Re planning application
for 1 The Grove *Garden Room*
FP/59/12. We have been
shown two sets of plans
Mark told us it was for
an office for his business.
We feel the building is too high
to the light into our garden
and very obtrusive.

SITE BLOCK PLAN

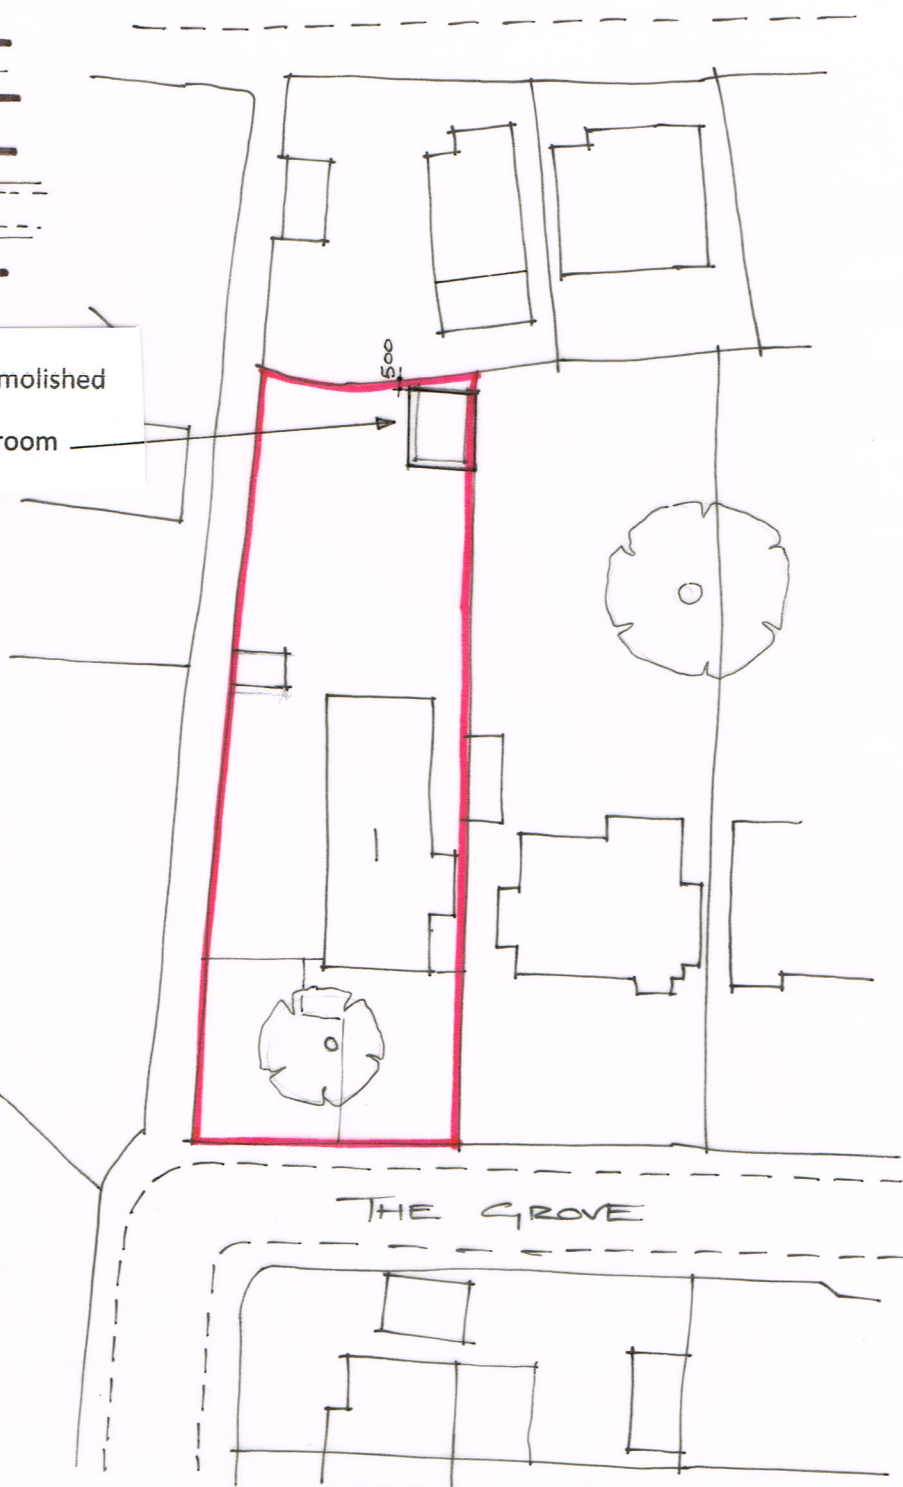
too close to our boundary
we did ask Mark if it
could be relocated further
back in the garden.
